Our Reference:
SWS-SUSXW-S106-011091

Date:
18/04/2018

Application to Connect to the Public Sewerage System - Section 106 Water Industry Act 1991. Location: Former Hares of Rustington, Station Road, Rustington, Littlehampton, West Sussex, BN16 3BH.

Scale	Paper Size	Date	Drawn By	Checked By
1:125	A1	JUNE 2017	JH	CH
Project No.	Drawing No.	Revision		
RRL012	505	P3

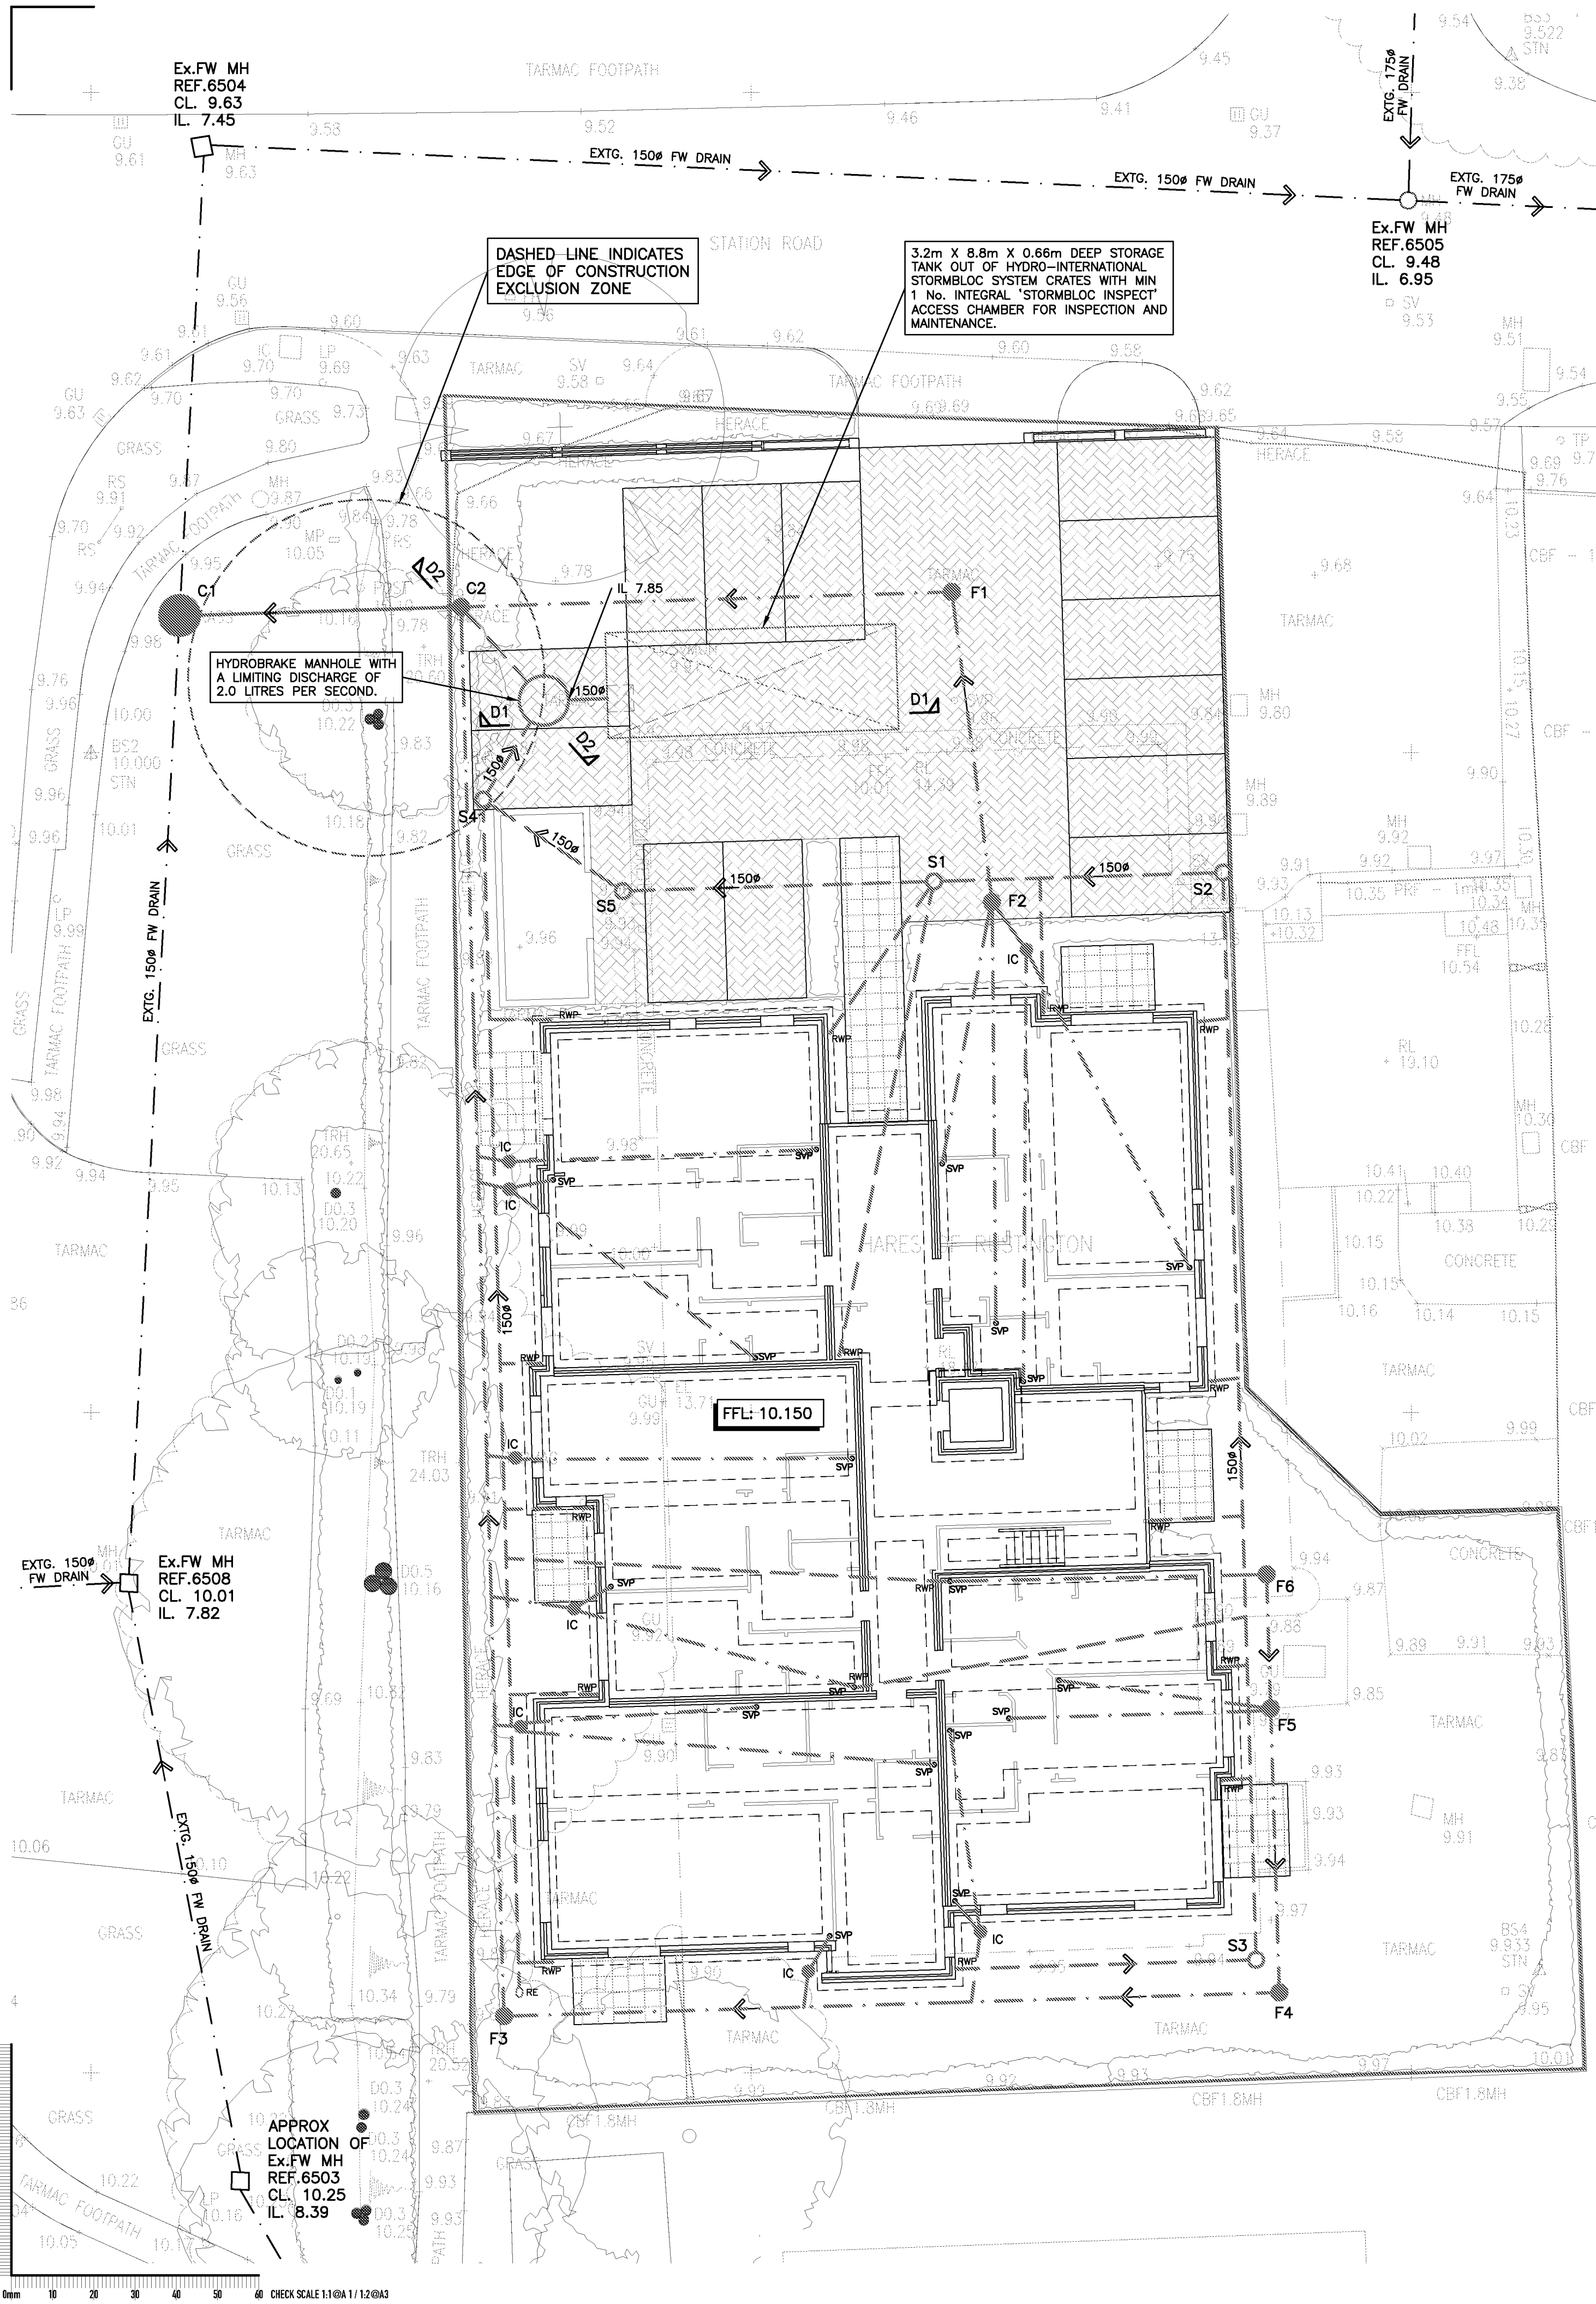
We refer to your recent application to connect to the public foul sewer at the above location. We are pleased to advise that your proposal, as shown on your drawing 505 Revision P3 Dated 06/12/2017, is approved subject to:

Please ensure connections onto the public sewer are no greater than 90 degrees and therefore against the flow.
